I'm writing in regards to File No.: CAO17-001. The environmental impact concerns I have are the following:

**From:** Robert Evans  
**To:** [Lauren Anderson](#)  
**Cc:** [revansconsult@comcast.net](mailto:revansconsult@comcast.net)  
**Subject:** In response to File No. CAO17-001:  
**Date:** Monday, May 1, 2017 4:47:50 PM

Our family home is located at 9620 SE 68<sup>th</sup> Street. Following our review of the proposal to do a buffer averaging of a piped watercourse we have some concerns that need to be addressed.

TOPOGRAPHIC & BOUNDARY SURVEY  
NE 1/4 OF THE NE 1/4 OF SEC. 30, TWP. 24N., RGE. 5E., W.M.  
TAX PARCEL NO. 3024059098  
NIEDRMAN RESIDENCE  
6800 96TH AVE SE  
MERCER ISLAND, WA

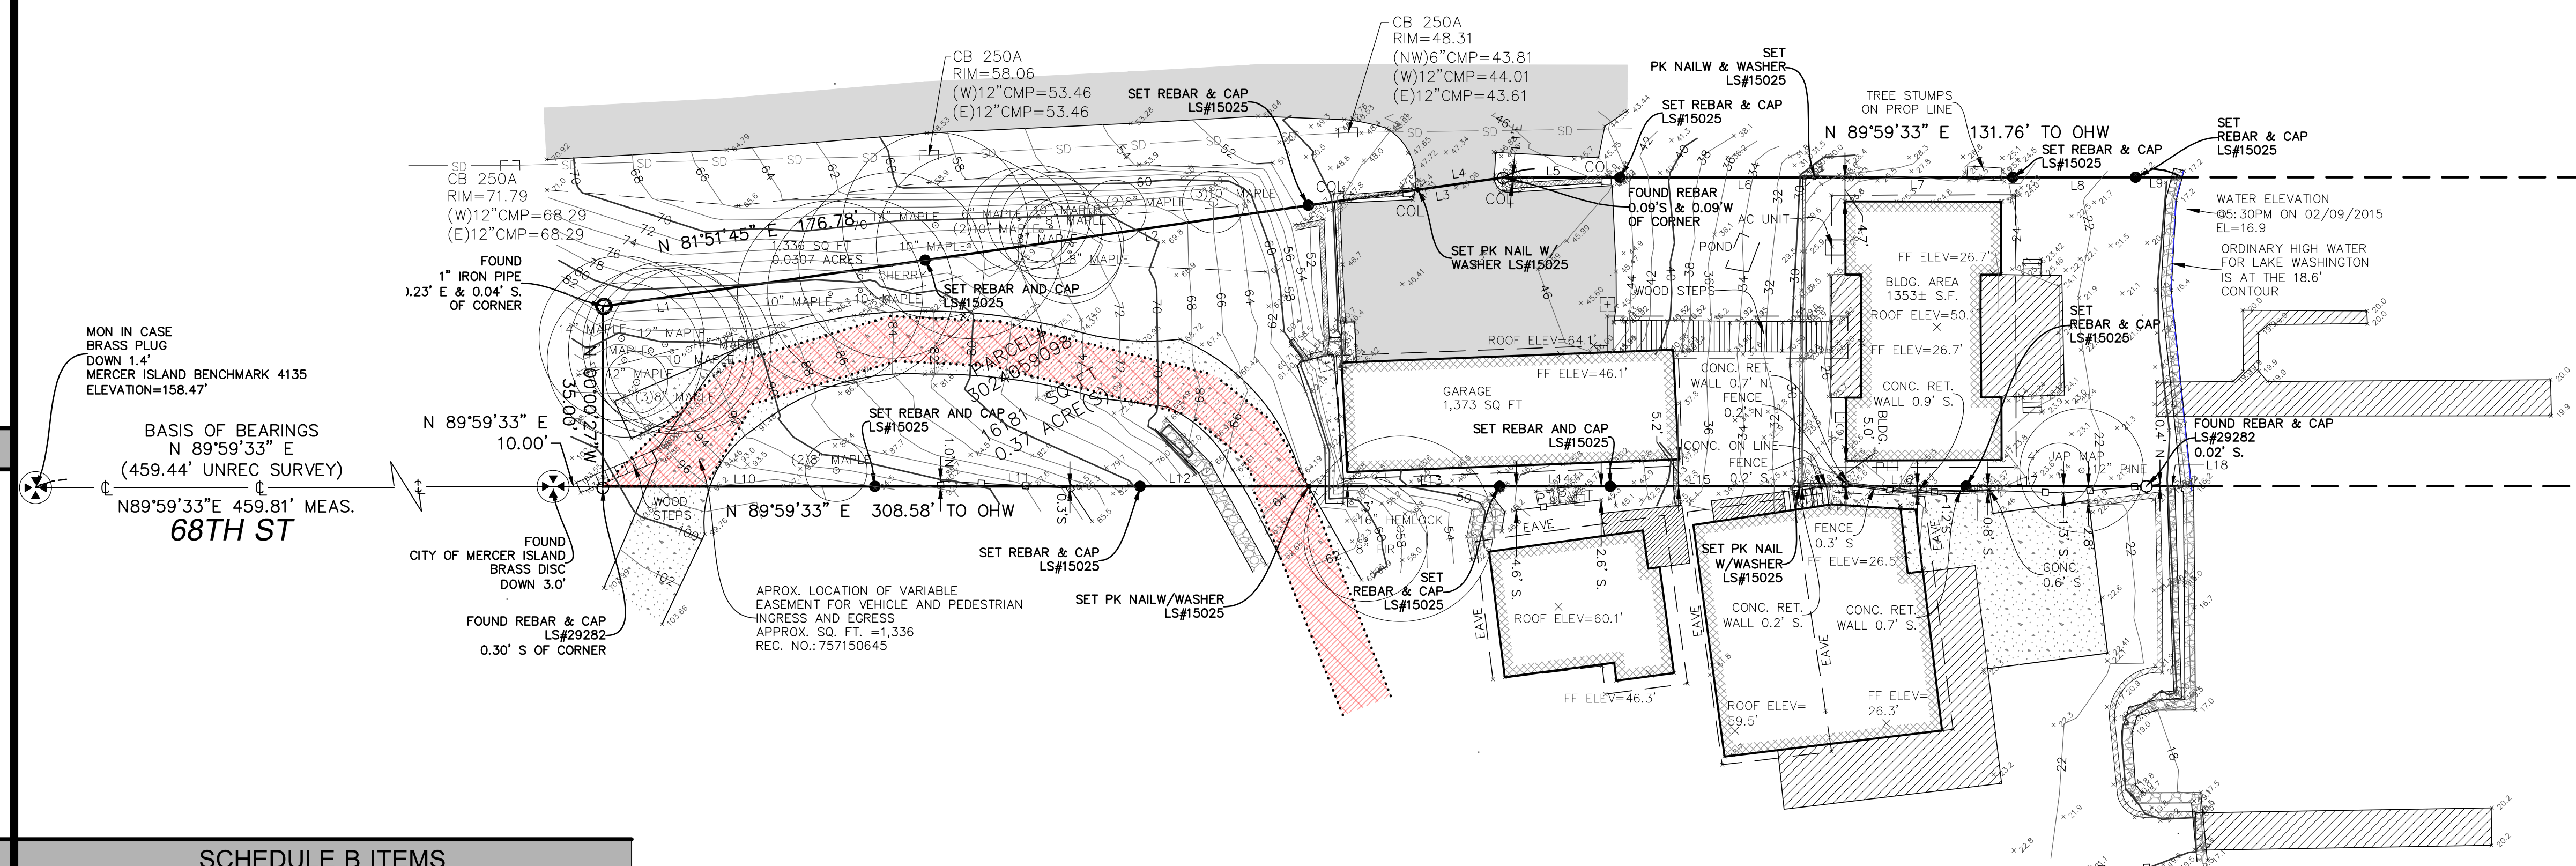
1. The removal of the mentioned concrete parking pad may cause the hill to erode thus causing mud slides or trees to topple.
2. The previous owners of the Neiderman's property asphalted the graveled parking area. I do not believe the asphaltting was done with permits required by the City thus not currently recorded by the City of Mercer Island.
3. The existing buffer also needs to be shored up and inspected as it was done without required permits. Also, there is a new stairway along the buffer that may cause instability to the hillside.

1. The location that the Niederman's are proposing as the "restoration area" is directly above a very steep greenbelt. Any change in water drainage will likely cause further erosion to a bank that has been established for 40+ years.
2. The location which the concrete is being removed is not an RV parking space but rather the old driveway that was covered by the current access road. The runoff that is coming off the road currently is not diverted down the steep slope.
3. The existing piped watercourse is limited to capturing runoff from the private driveway not to mitigate additional or change in runoff.

In short our concerns by changing the water course above this hill will most certainly cause instability and increased erosion. This could cause a this hillside to slide causing tremendous damage to our home and access road.
